Your Ref: OWPC15768
Our Ref: BR/229/17/PL 11-08-2017
Please ask for:
Mr S Davis

Erection of 4 No. dwellings, 1 No. detached garage, parking & alterations to existing access & driveway (resubmission following BR/200/16/PL).

Land to rear of 41 - 47 Pevensey Road Bognor Regis

Thank you for your internet representation made on 8th October 2017 which has been recorded as '**an objection**' with the comments as follows:

DRAWING TITLE
Block & Location Plans and Site Section

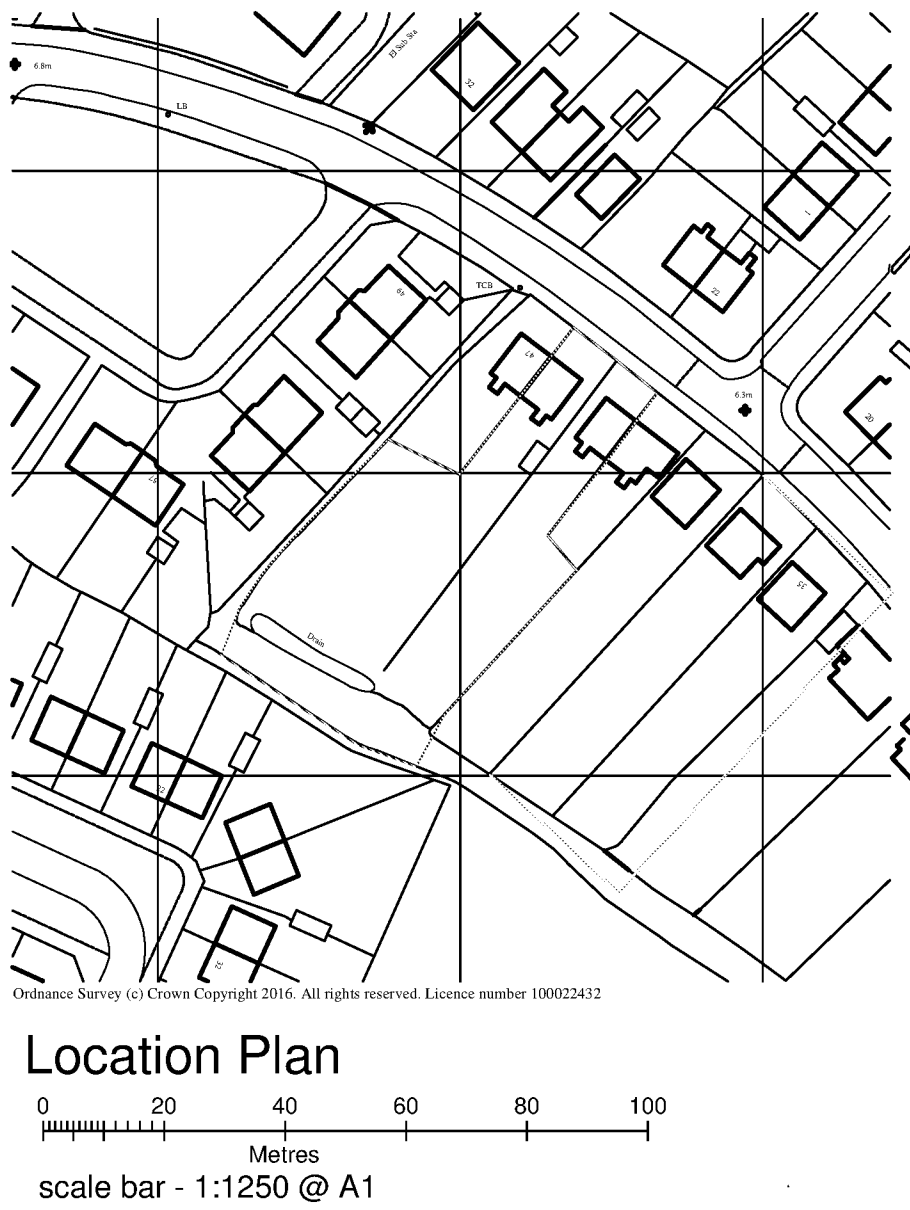
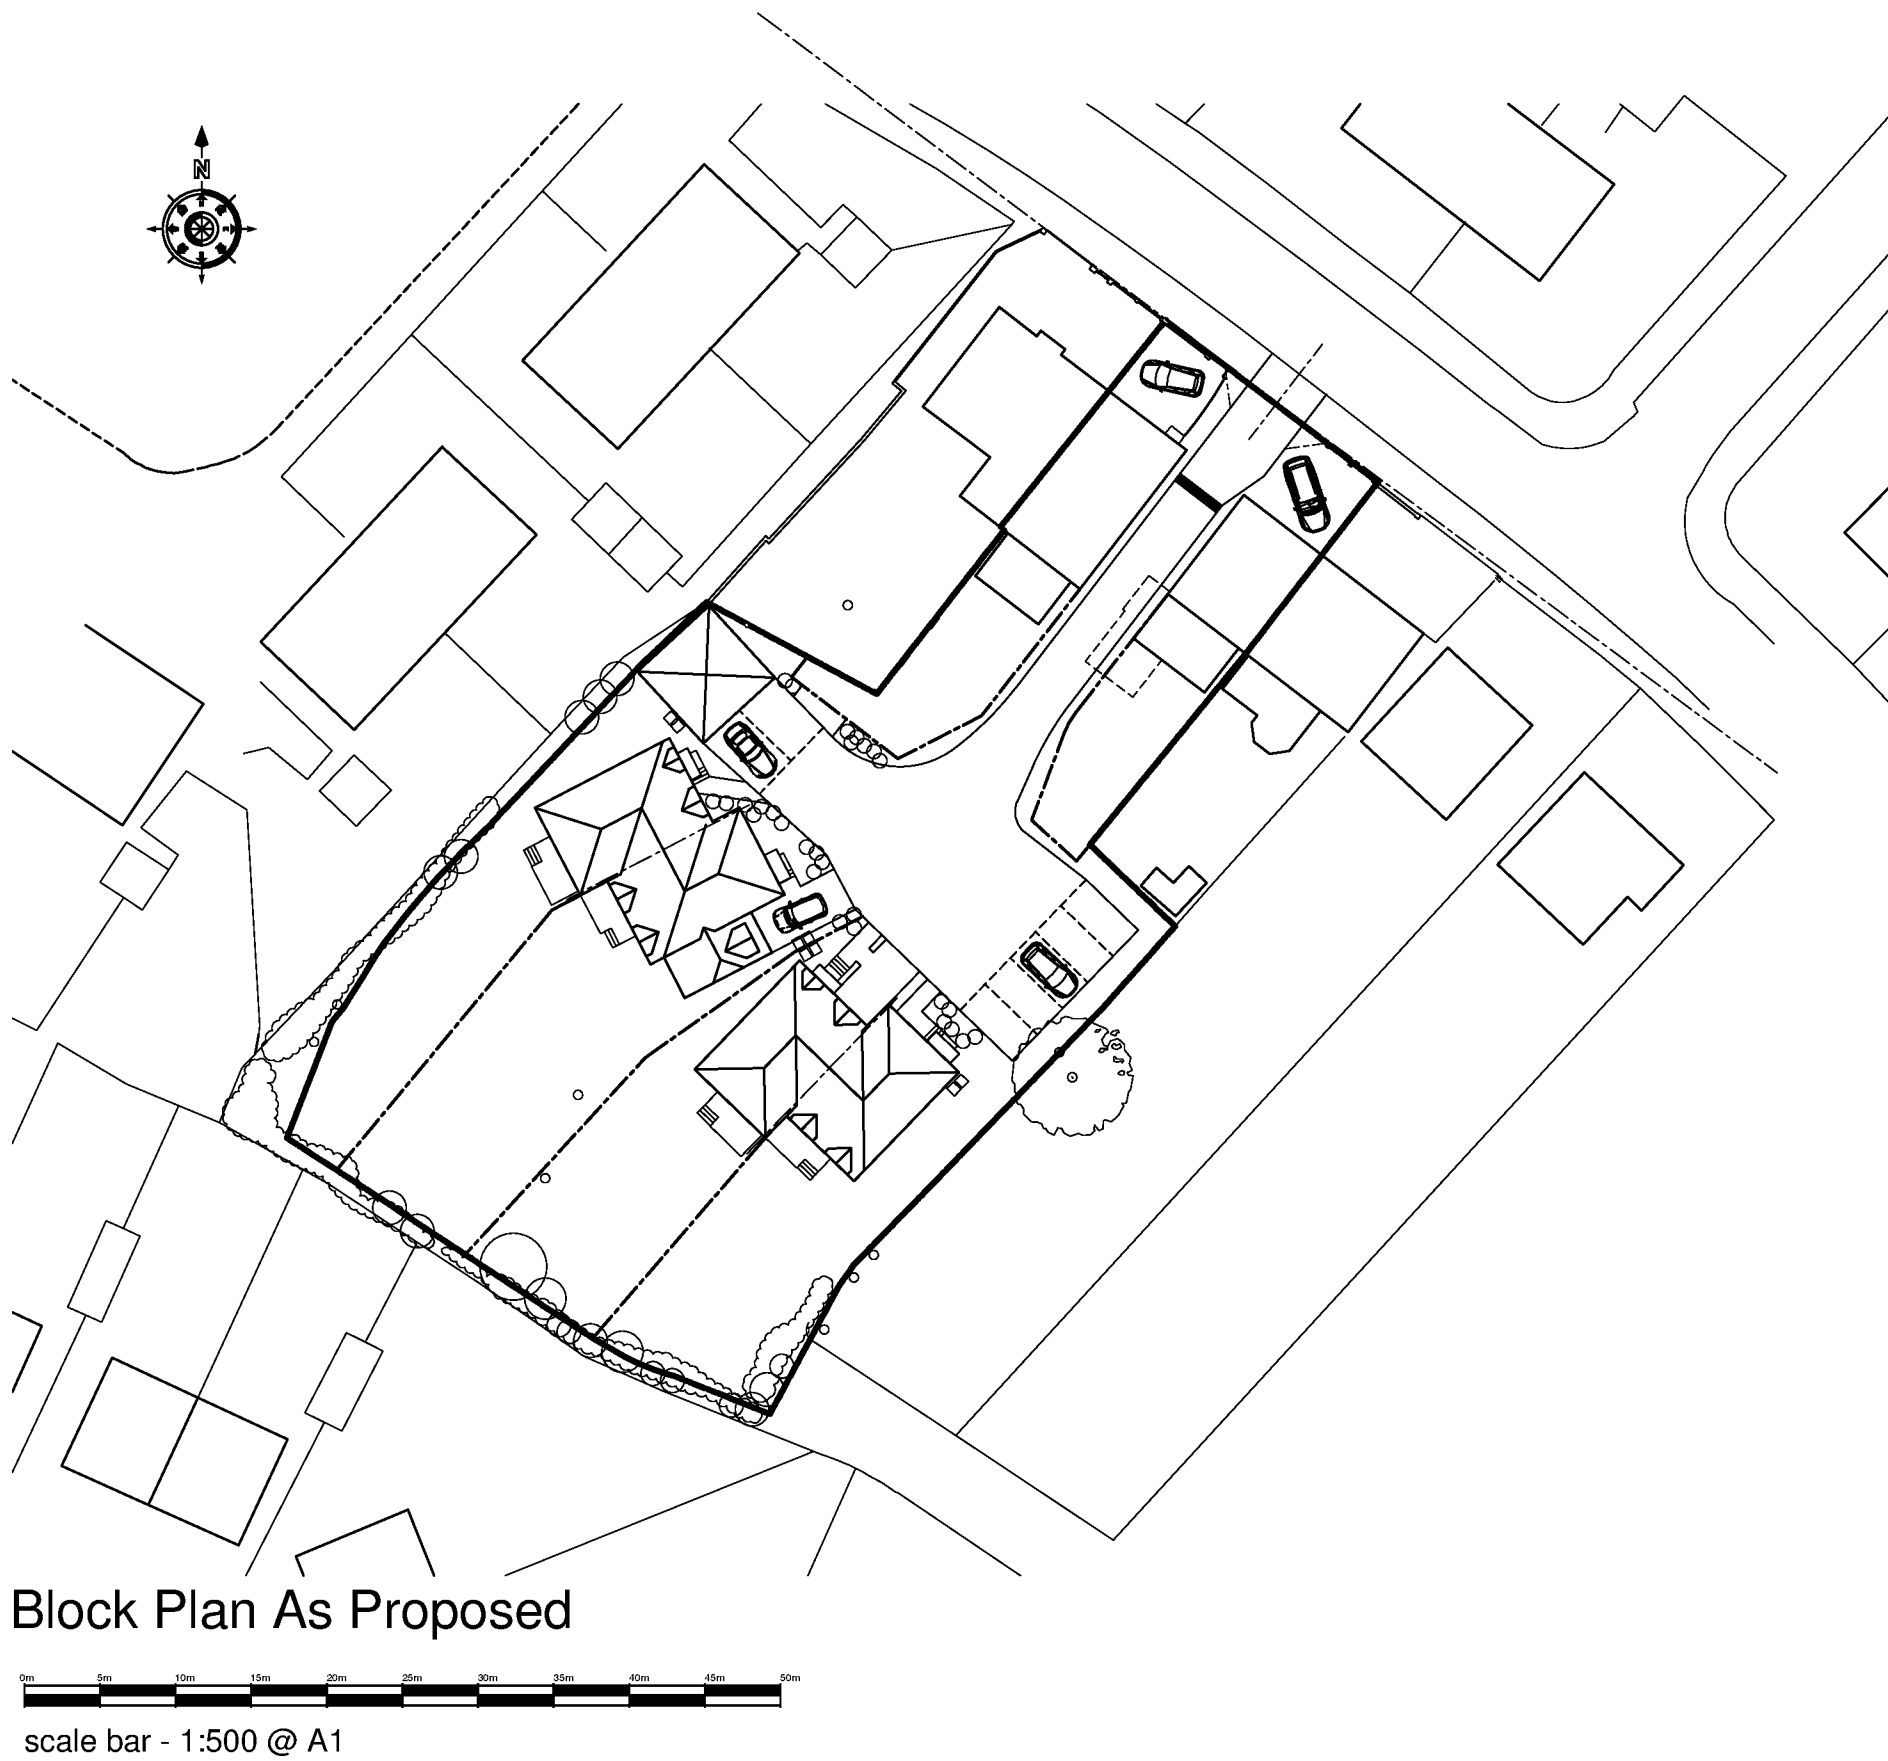
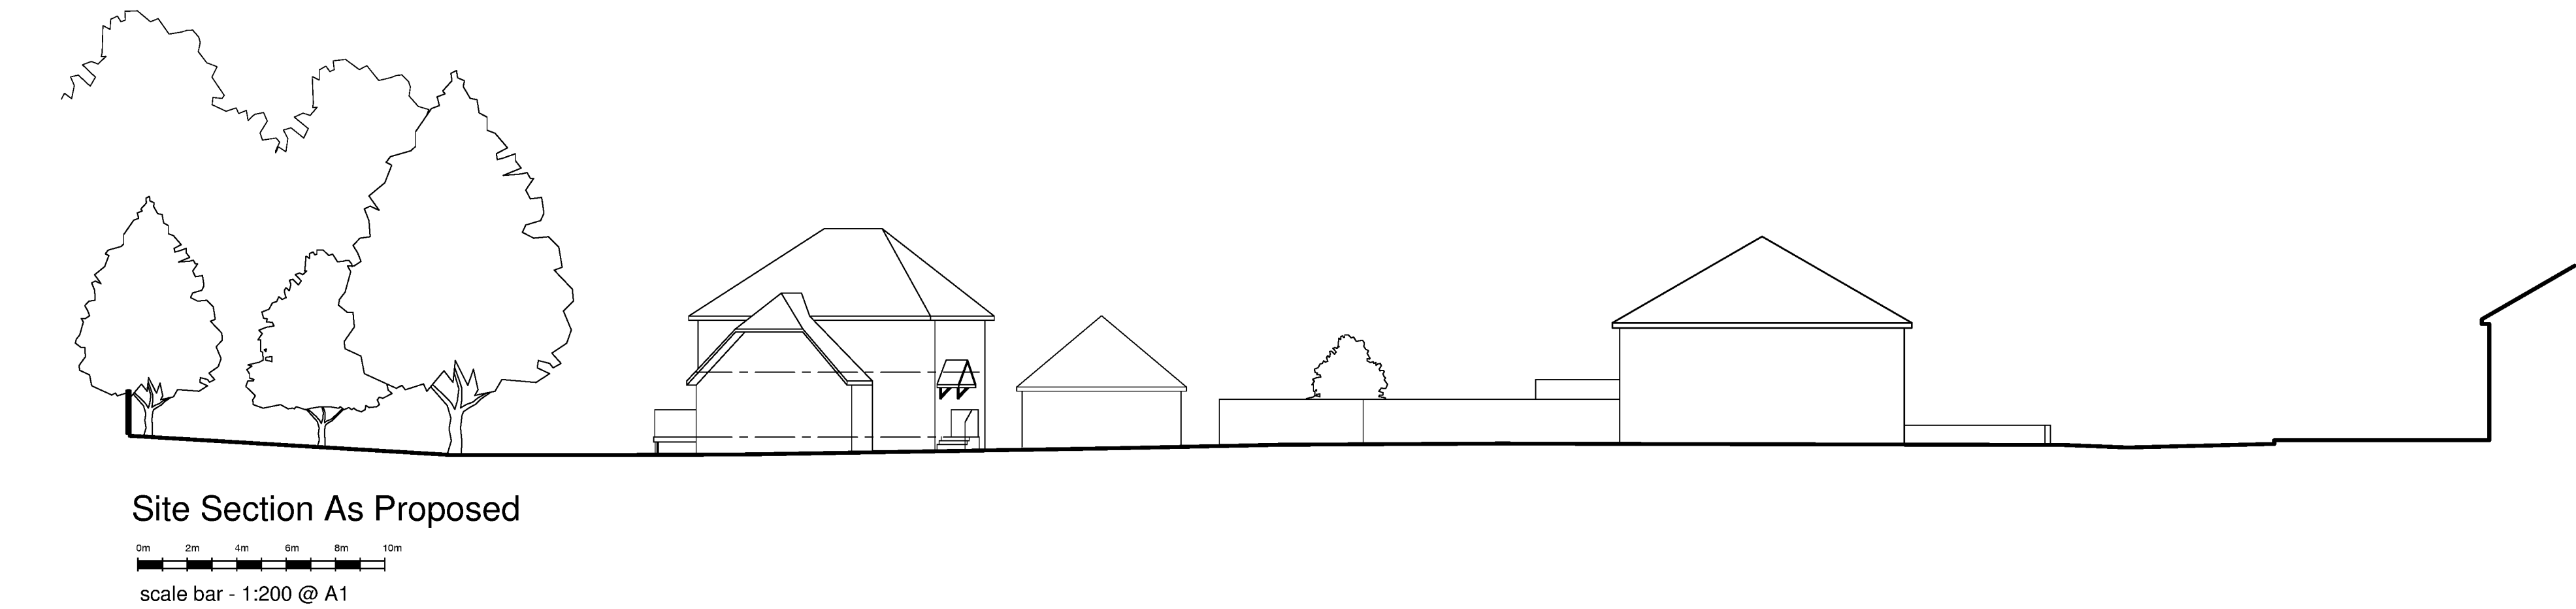
1 The proposed new access road into the new development site is too close to the existing junction of Pevensey Road and Frith Road. Although both are in the 20 mph low speed zone the 20 mph speed limit is not observed by the majority of drivers, nor is it enforced.

The proposal to use the two very narrow footpaths lining the new access to the proposed development as refuse and recycling collection points will force pedestrians to walk on the road. This is unacceptable.

The site layout plan shows turning provision for a Fire appliance which is unlikely to be available due to parking of multiple vehicles for each house and visitors parking at each of the houses at the same time.
